Your Ref :  
Our Ref : EP/107/18/NMA

**Section 96A of the Town & Country Planning Act 1990 (as amended)**  
**Town and Country Planning (Development Management Procedure) (England) Order 2015 (as amended) - Article 10**  
**Application for non-material amendment following a grant of planning permission EP/146/15/PL relating to a ASHP to rear elevation to Plot 1. Install a ASHP to left hand side elevation to Plot 2. Slaters Cottage, 3 The Street, East Preston,**

Rear Elevation (North)

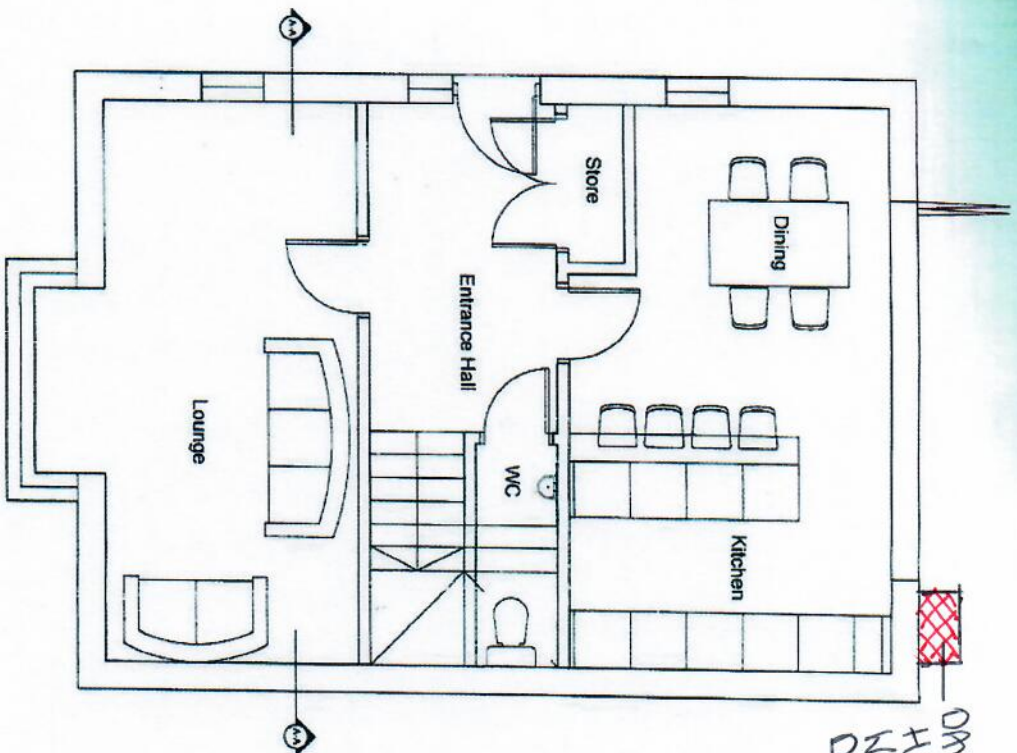
The reasons that these proposals have not been accepted as a Non-Material Amendment is because they are not considered insignificant in respect of the impact on neighbouring dwellings. The 'Air Source Heat Pumps' are close to potentially noise sensitive dwellings and air source pumps are inherently noisier than ground source heat pumps. The proposal cannot therefore be considered under section 96A of the Town and Country Planning Act 1990. For further guidance you are advised to contact Anna Appleton of the Council's Environmental Health Division on email [anna.appleton@arun.gov.uk](mailto:anna.appleton@arun.gov.uk) tel. no. 01903-737676.

For your information, ASHP units should be placed as far away from openable windows as possible and mounted using appropriate sound isolating mounts. They should maintain a minimum glazing spec of appropriately rated glazing components (i.e. 4-16-4 argon / krypton filled unit which would achieve in the region of 29 dB Rw (C;Ctr) or better still a 6-14-4 argon / krypton filled unit that would reach an Rw value of c.35 dB).
